My Ref: 2021/0950
Your Ref:
Date: 2nd September 2021
Enquiries to: Hannah Andrew
Direct Dial: 01226 775752
E-Mail: hannahandrew@barnsley.gov.uk

Discharge of condition 8 (EVCPs) of Planning Application 2019/0809 (Reserved Matters for 360 dwellings)

Land off Lingamore Leys, Thurnscoe, S63 0PG

Dwg No	2066-Y2-04-100	Rev	A
--------	----------------	-----	---

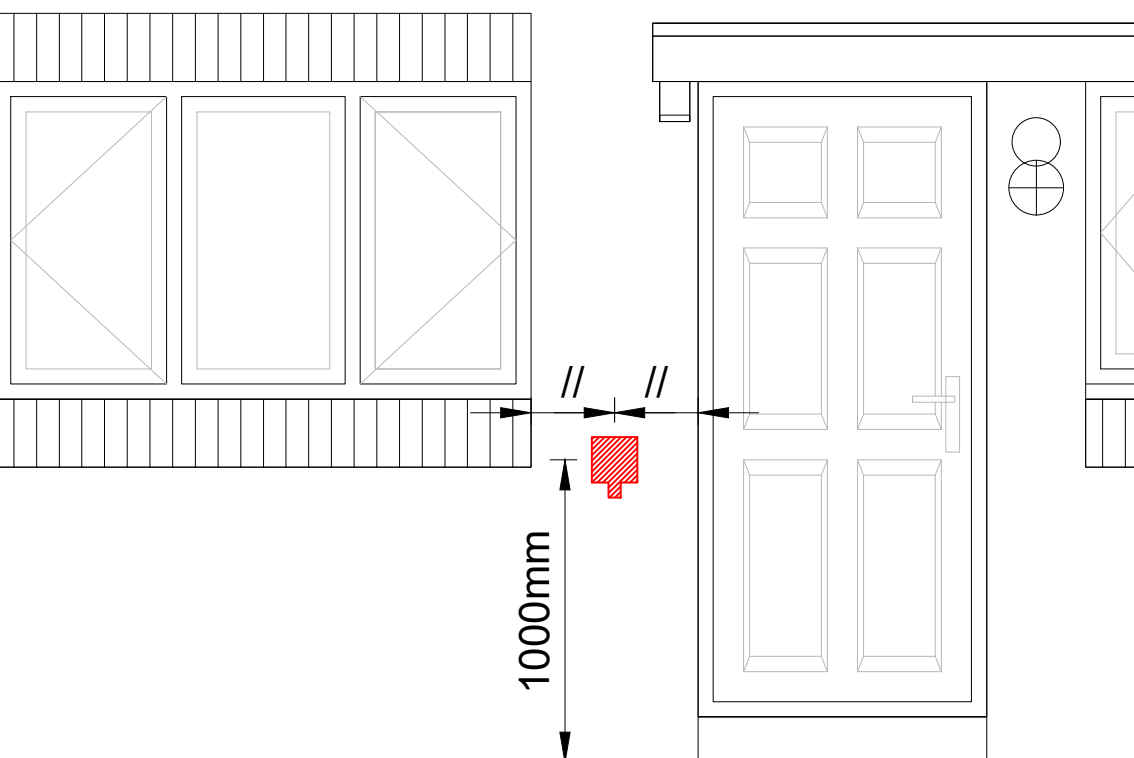
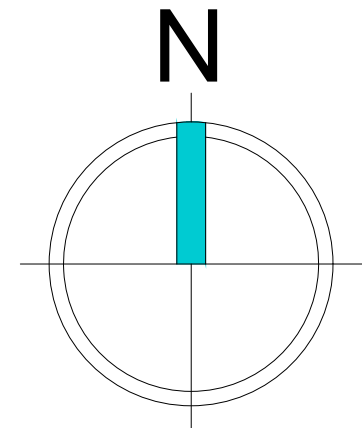
The submitted plan, Electric Vehicle Charging Points Ref: 2066-Y2-04-100 Rev A, confirms the location of the proposed charging points and that one is proposed for each house. This is in accordance with the requirements as set out in the Sustainable Travel SPD. However, the type of charging point offered is stated on the plan to be:

- 1) Single 13amp external Socket to be Installed within garages or adjacent driveways & parking spaces.
- 2) Minimum IP66 Rated socket when positioned externally.
- 3) Positioning of socket to be 1000mm from Ground Level and located within min 5m of parking space.
- 4) Every dwelling to have a EVCP

'The connection will be a 7.3kw 32A radial circuit from the consumer unit to each charging point location with a 13amp external socket (Mode 2) connection for electric vehicles).'

As confirmed in my email (23/08/2021) this proposed specification is insufficient to comply with current Local Plan Policy and the accompanying guidance.

Obligations with Section 8 of the SPD providing the minimum requirements for electric vehicle charging points. At paragraph 8.2 reference is made to the Barnsley MBC Air Quality and Emissions Good Practice Planning Guidance as providing further guidance on the level of mitigation required: including at Appendix 4 the Electric Vehicle Charging Point Specification which requires 'Mode 3' charging points.

For the reasons set out above, the proposed is insufficient to discharge this condition and does not comply with the Local Plan Policy position. As you have stated that no amended or additional information will be proved I must refuse this application and advise that the condition remains undischarged.
